Response to Submissions

Building R5
One Sydney Harbour

Submitted to Department of Planning and
Environment
On behalf of Lendlease (Millers Point) Pty Ltd

13 May 2019 | 2190302

Raised Planting and Lawn

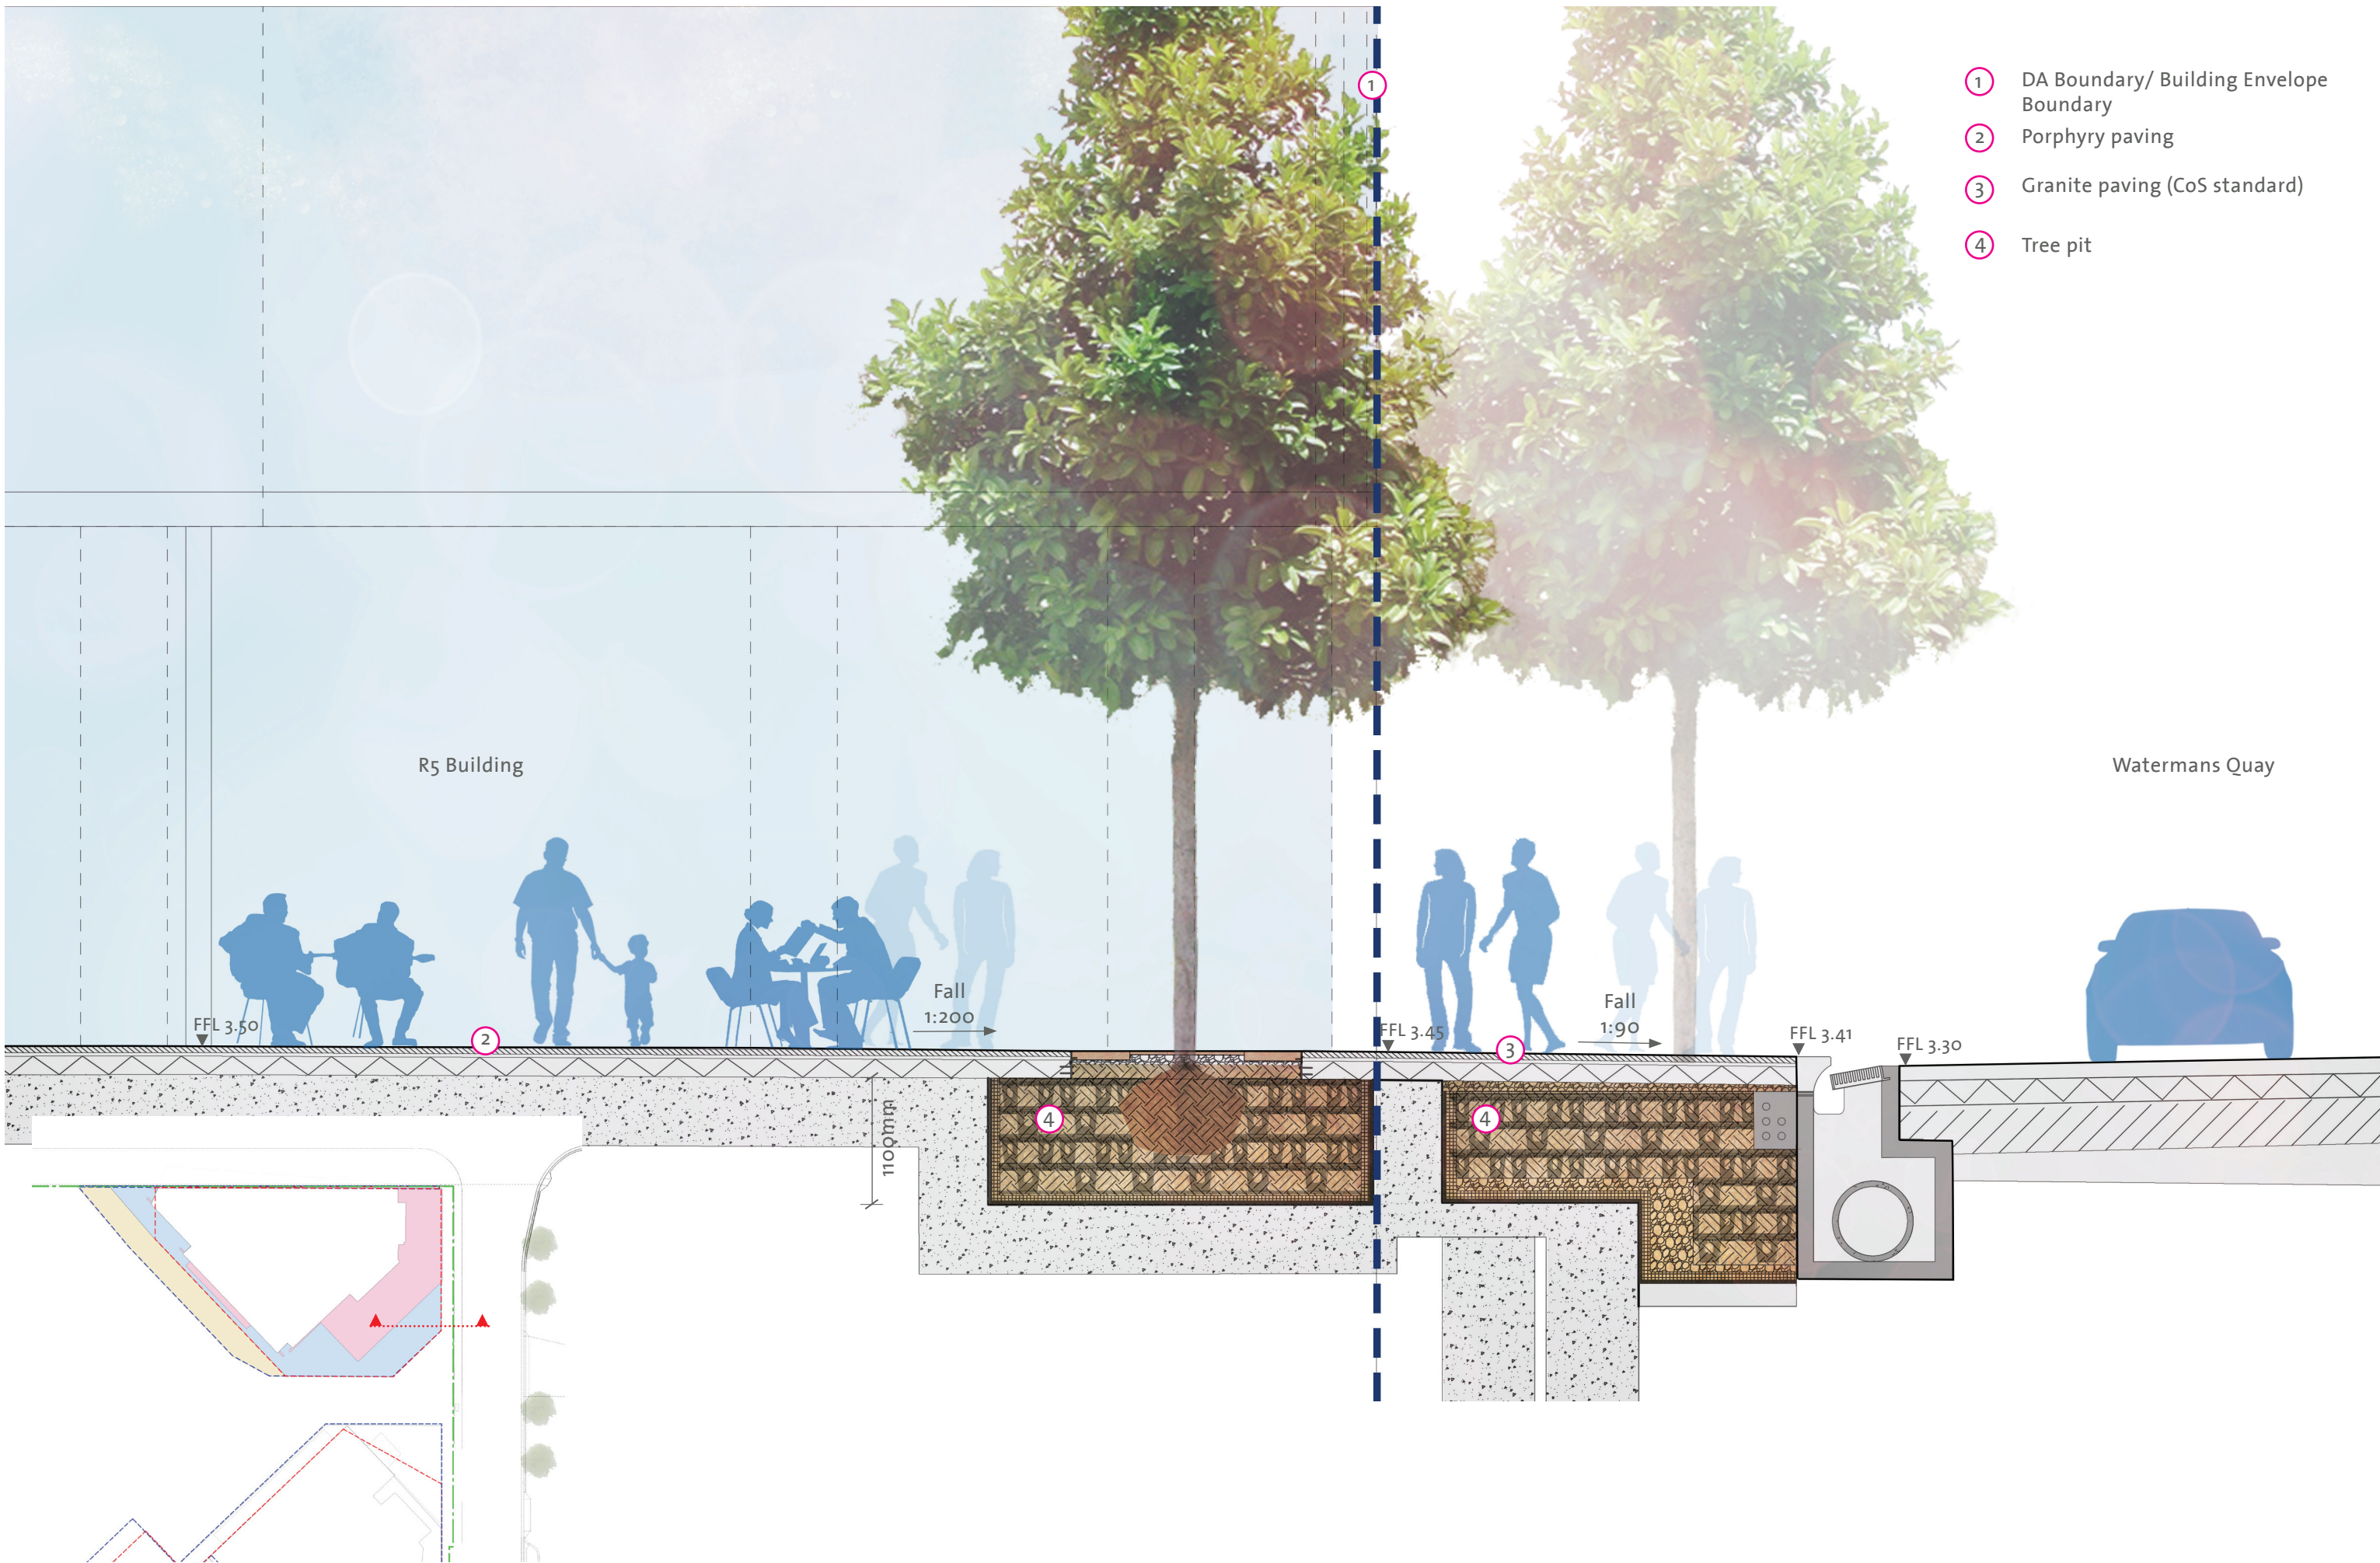
<p>23.0 Ground Floor Plaza Tree Planting</p> <p>No design detail has been submitted for the 4 trees proposed at ground level within the plaza (and within the building envelope boundary) – see below.</p>	<p>Updated landscape plans are provided at Appendix J and detail the proposed tree planting. This is addressed at 6.1 above.</p>

Comments Received	Response
<p>23.1 Ground Floor Plaza Tree Planting</p> <p>There is insufficient information for the design of common open spaces. The plans are conceptual with no levels, minimal annotations, no planting design or schedules. This is not acceptable for a detailed (and final) development application.</p> <p>For example, the Section drawing (dwg RPB430-SE-R5004[G]) indicates 800mm depth raised planter with trees and shrub species is proposed, which is insufficient. A minimum 1000mm soil depth is required for tree planting on slab. In addition, there is no balustrade shown on top of the parapet at the edge of the perimeter maintenance path. The design is not compliant with BCA and Working at Height regulations.</p> <p>The landscape design requires amendment to provide adequate soil depth for tree planting on slab and the inclusion of safety balustrades. Details on the design of raised planters and free standing pots, soil depth and volume for trees on slab, plant schedule are missing.</p>	<p>Updated landscape plans are provided at Appendix J and detail the design of common open spaces. These detailed plans confirm that the proposed design is compliant with the BCA and that appropriate soil depth can be achieved for the proposed planting.</p>

<p>23.2 Common Open Space Generally - Level 2 and Level 26</p> <p>There is insufficient information for the common open space. The plans submitted are conceptual in nature with no levels and minimal annotations. The design of covered shelters, trellis with climbers, details on whether furniture is fixed, depth of planters and free standing pots, soil depth and volume for trees on slab, location of balustrades and /or safety anchor points have not been provided.</p>	<p>Updated landscape plans are provided at Appendix J and detail the design of common open spaces.</p>
